**Consultation Response from KC,
 Highways Development Management**
2019/94075 4, Olney Street, Slaithwaite, Huddersfield, HD7 5EG
Erection of pair of semi-detached dwellings
Date Responded:05/02/20
Responding Officer:CNB
Responding Ref:K1-33/22

Proposed site plan 1:200.

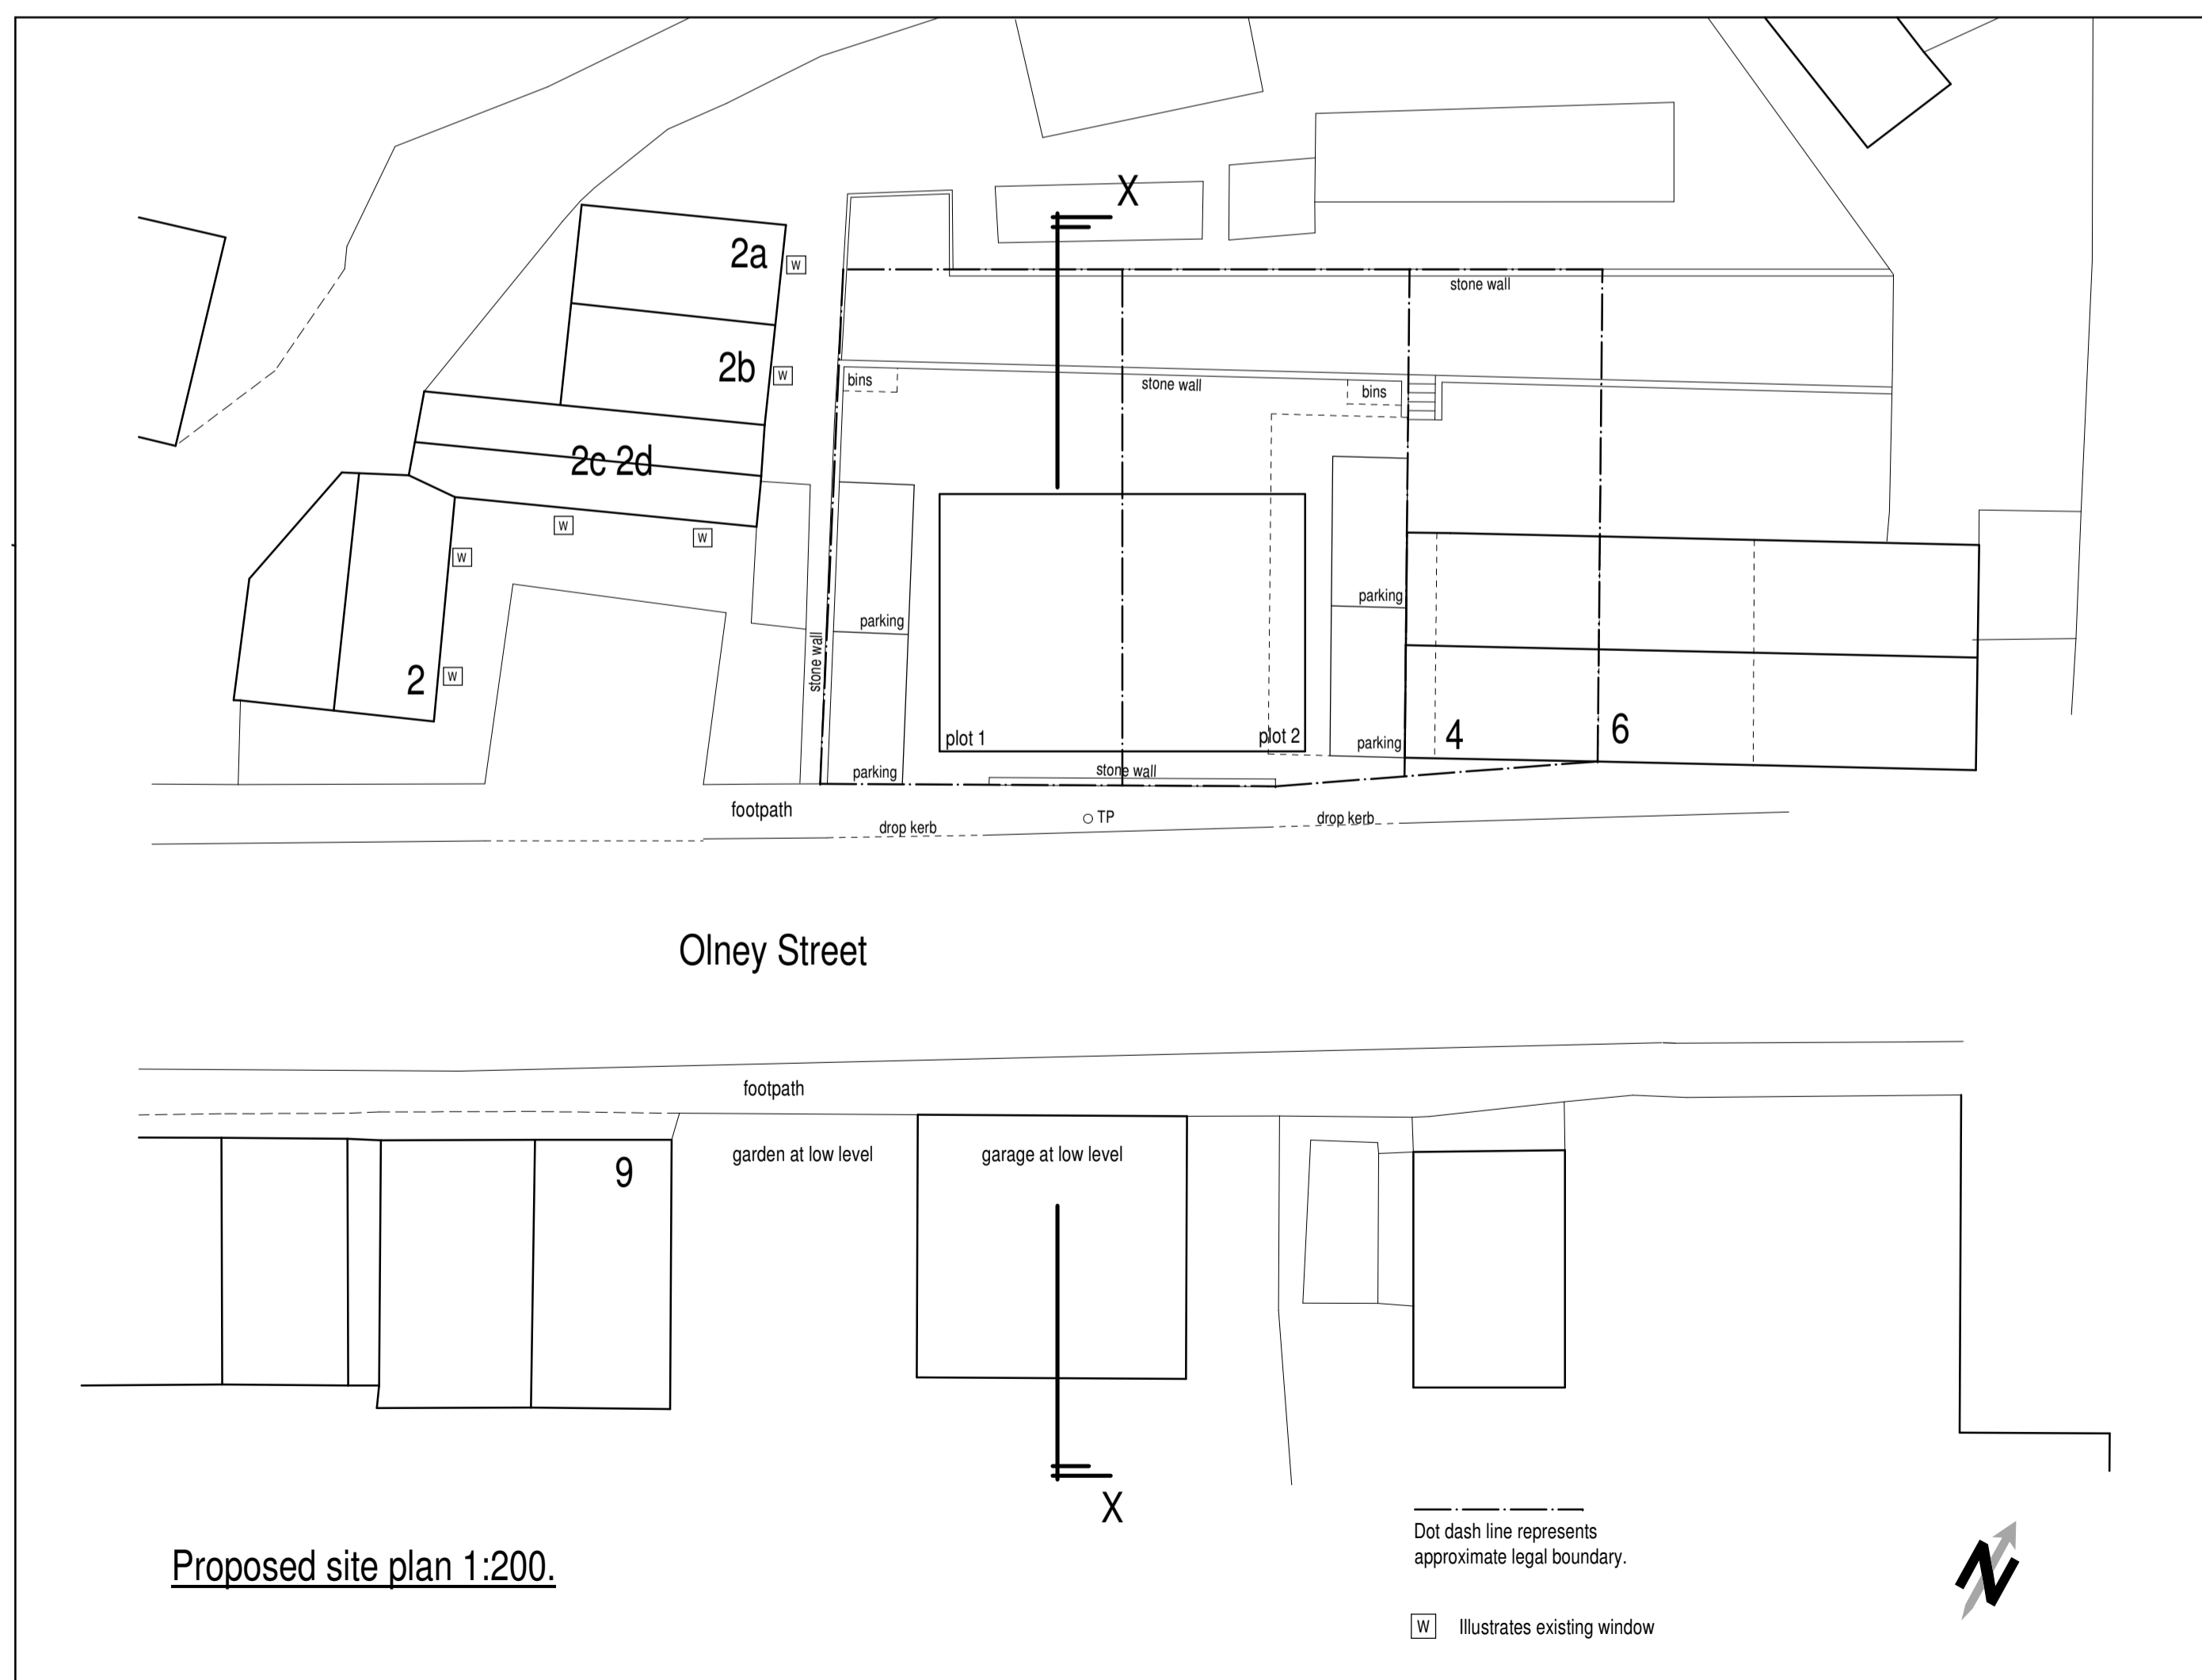
The proposed dwellings are three bedroom and as such we would like to see two off street parking spaces provided with each dwelling to be seen as being fit for purpose. Drawing number ODP01 shows two tandem spaces per proposed dwelling and this is acceptable. The only highways concern was the loss of off street parking at the existing dwelling due to the demolition of the garage to make way for the proposals and the displacement of this parking on to the highway, the previous permission retained the garage. There is existing on street parking occurring on Olney Street and some space may be available for the displaced vehicles. As the road is a cul-de-sac serving approximately 40 properties the traffic flows are expected to be low and the chances of obstruction to multiple vehicles will be at a minimum. On balance we feel we can accept the parking layout.

Drawing ODP01 shows the location of bin storage points, these would not be suitable as collection presentation points as they are to the rear of the properties and behind parking areas, where the bins may become trapped. A bin collection presentation point for the two proposed properties and the existing property at No4 should be clearly marked on a drawing. These should be so located that they are accessible to a cleansing operative but not where they would cause an obstruction of the footway or highway for road safety reasons. This should be conditioned, but if the information can be suitably provided prior to determination we would be happy to see the condition removed or amended as appropriate.

Before development commences, details of suitable storage, bin presentation points and access for collection of wastes from the dwellings hereby approved shall be submitted to and approved in writing by the Local Planning Authority. The approved details shall be provided before first occupation and shall be so retained thereafter.
